**Oberon White Granite Quarry Project (07\_0122); Exhibition of Environmental Assessment**

Thank you for your letter dated 17 November 2010 referring the Environmental Assessment for the Oberon White Granite Quarry to the Roads and Traffic Authority (RTA) for submissions.

Susie Mackay  
Development Assessment Officer  
Western Region

Figure 2.7 shows the existing intersection and proposed additional works.

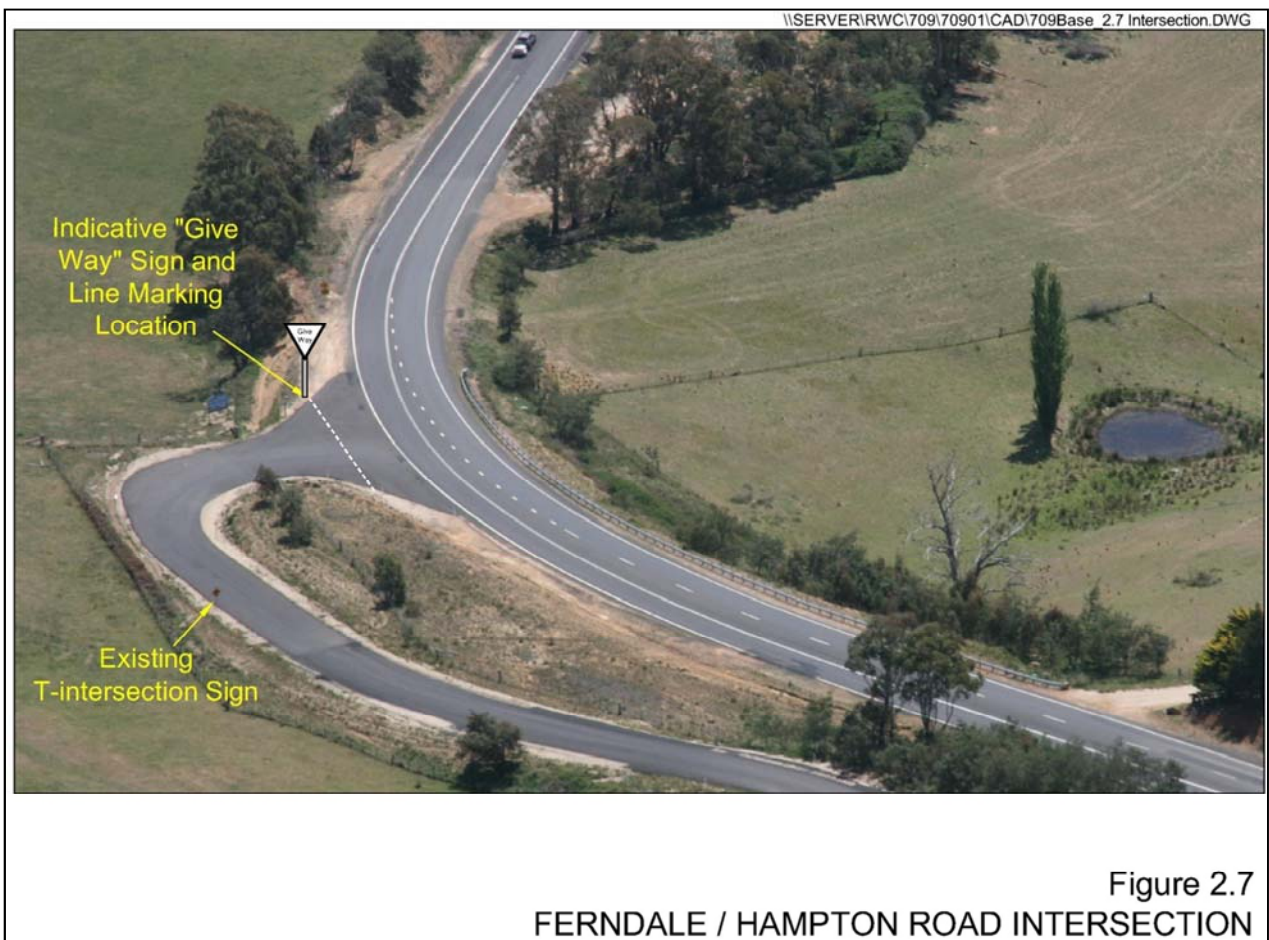
- All access to project site is to be via the intersection of Hampton and Ferndale Roads. No additional access will be allowed onto Hampton Road.
- Safe Intersection Sight Distance (SISD) of a minimum 225 metres is to be maintained in both directions along Hampton Road.

- 'Give Way' signs and should be installed on Ferndale Road at the intersection with Hampton Road in accordance with *Australian Standard 1742* and the *RTA Road Design Guide*. Installation of the 'Give Way' signs must be approved prior to installation in accordance with the RTA's *Delegation to Councils Regulation of Traffic*.

- A give way line is to be marked on Ferndale Road at the intersection with Hampton Road in accordance with Figure 4.8.35 of the *RTA Road Design Guide*.

- Reflective marker posts and 'In Fog Slow Down Hazard Warning Lights May be Used on Moving Vehicles' (G9-256) signs are to be installed on Hampton Road 225 metres from the intersection with Ferndale Road in both directions. The applicant is to consult with and be given final authorisation from the RTA as to the precise location of the reflective markers and signs.
